Subject: 2023-62-91564 Barnsley Road Land off Barnsley Road, Denby Dale, RE: 2023-91564 Overlooking 19 and 21 Inkerman Way

2023-62-91564 Barnsley Road Land off Barnsley Road, Denby Dale, Huddersfield

Barnsley Road 27 Houses comments on overlooking and distances

Drawing Number: QD2092-00-04

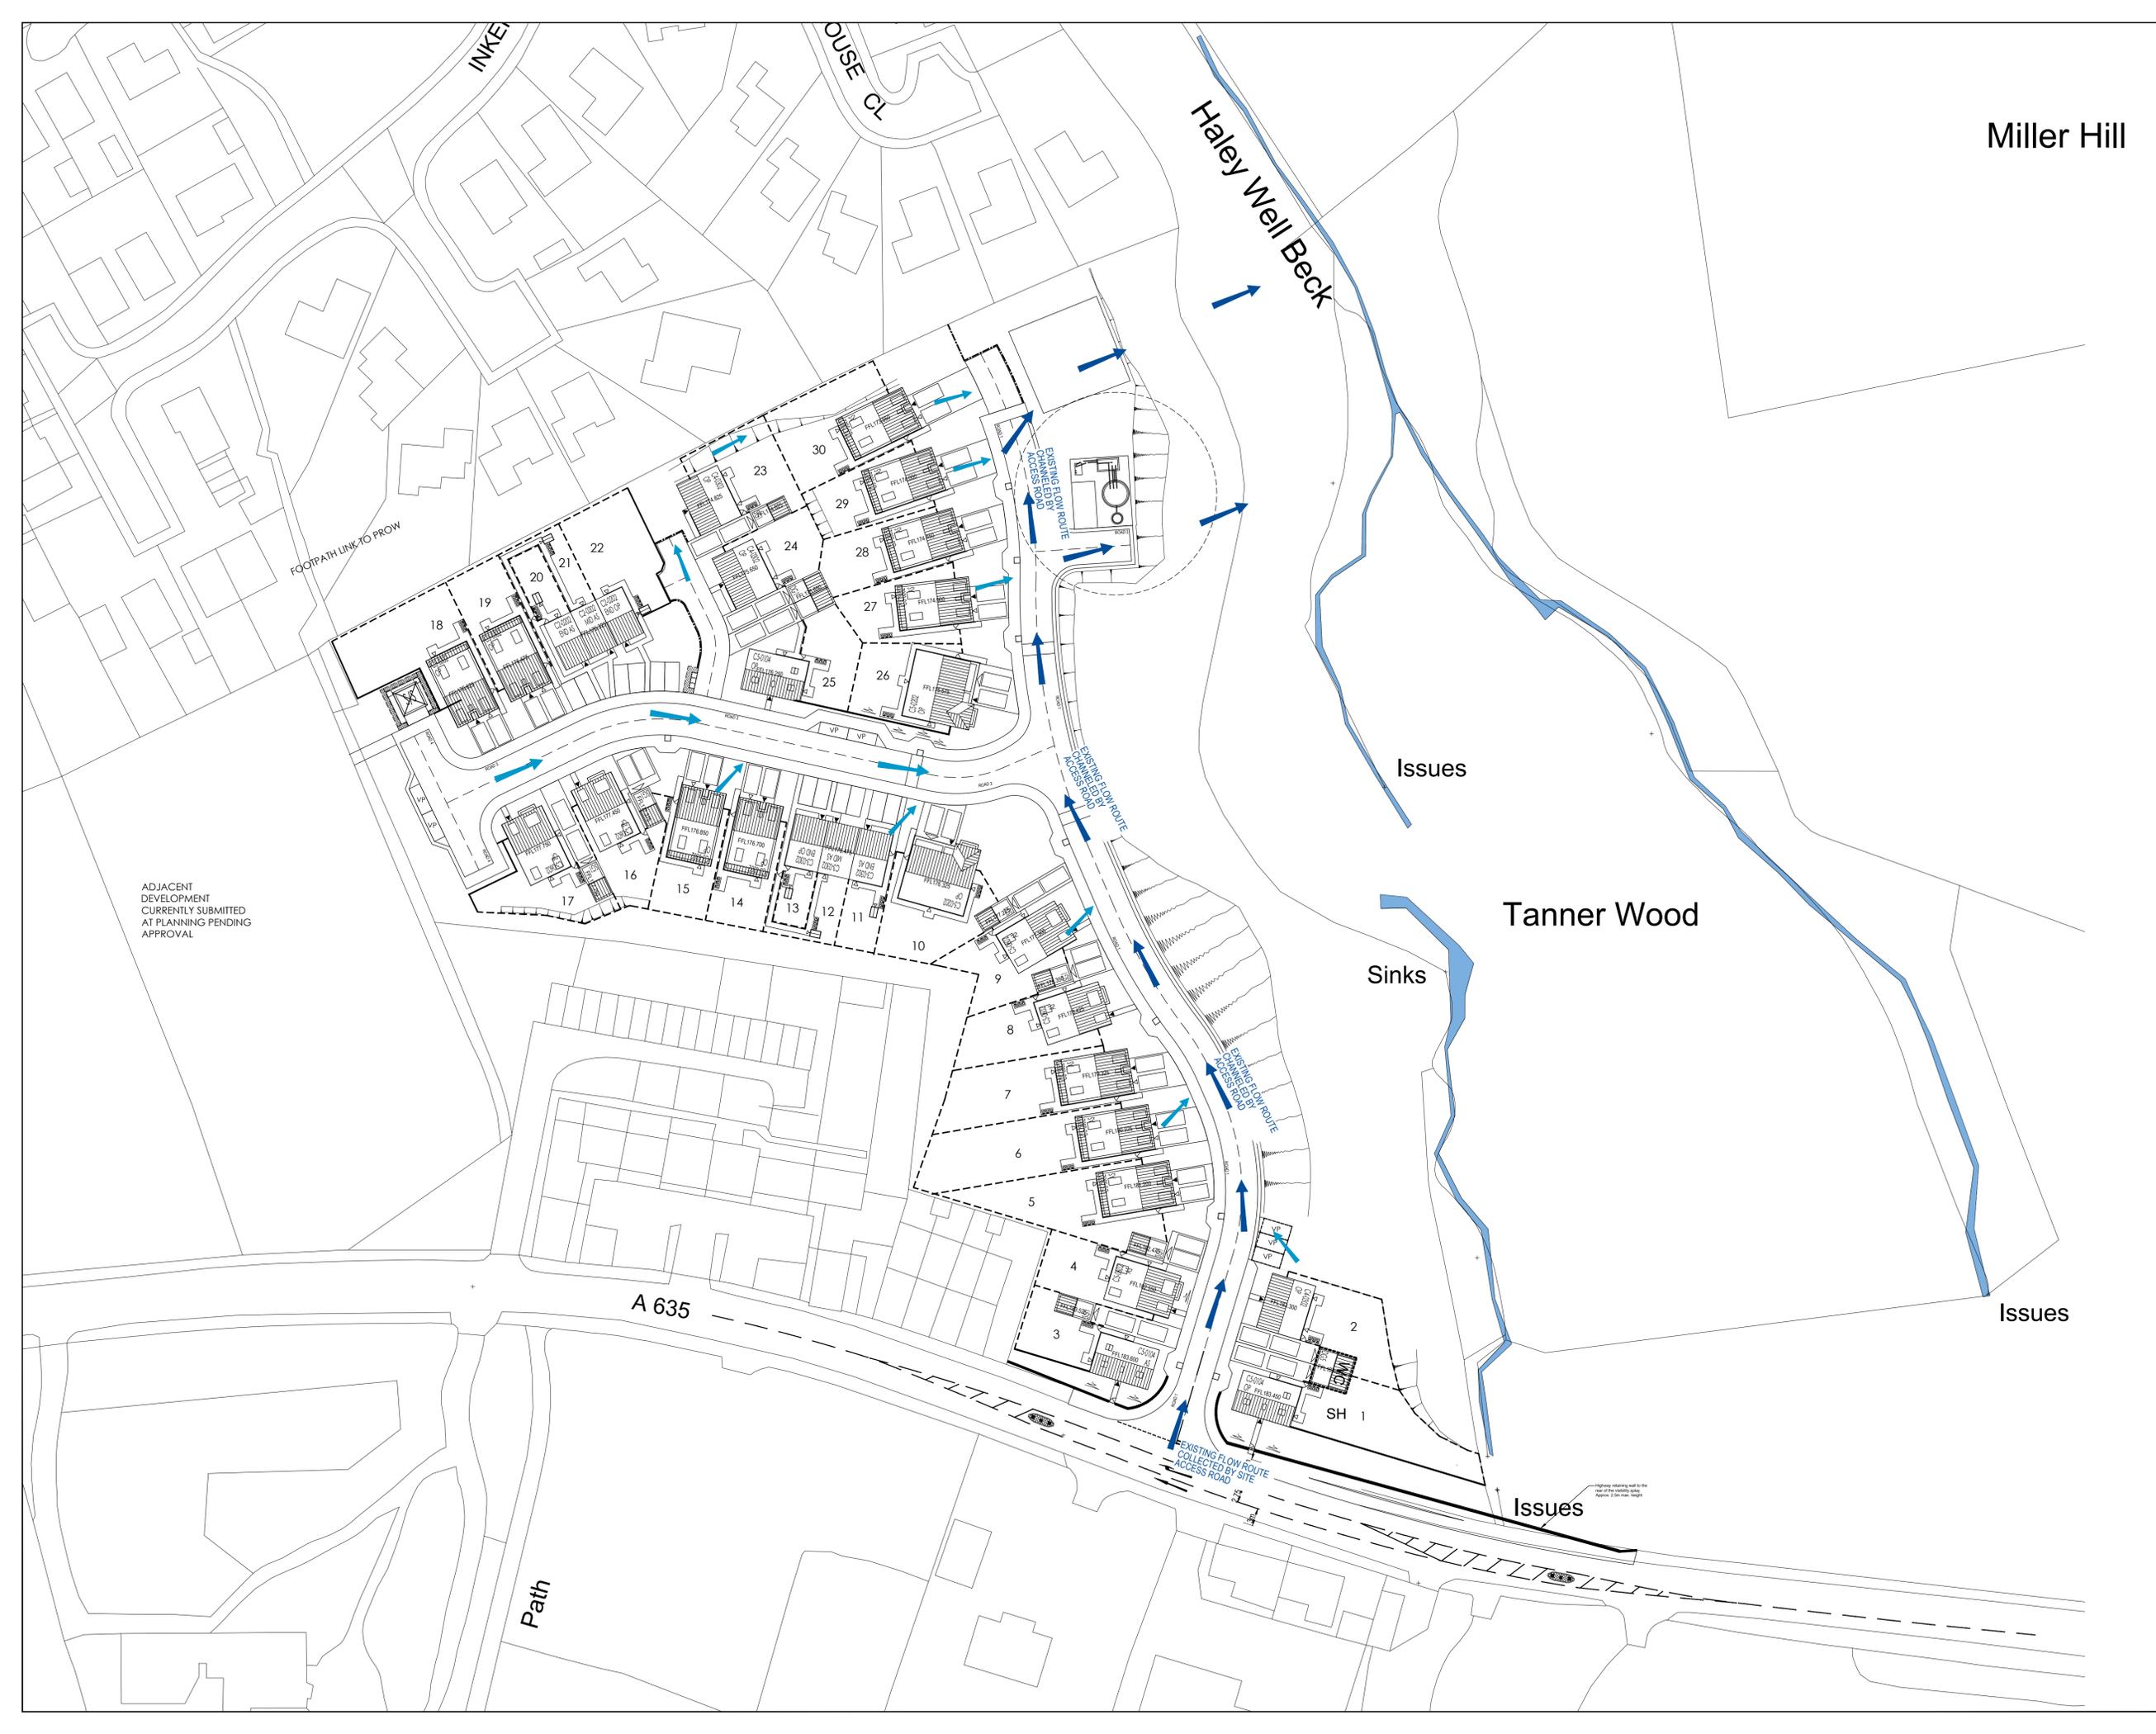
Flood Routing QD2092-00-04

There should be a French land drain between the new development and the existing properties

[this was implemented on the adjacent development along Barnsley Road Kirklees-Planning Ref 91836]

The proposed flood plan indicates that the flow across the back of the properties in Inkerman Way and Broomhouse Close risk of flood flows from plots 19, 20, 21,22 and 27
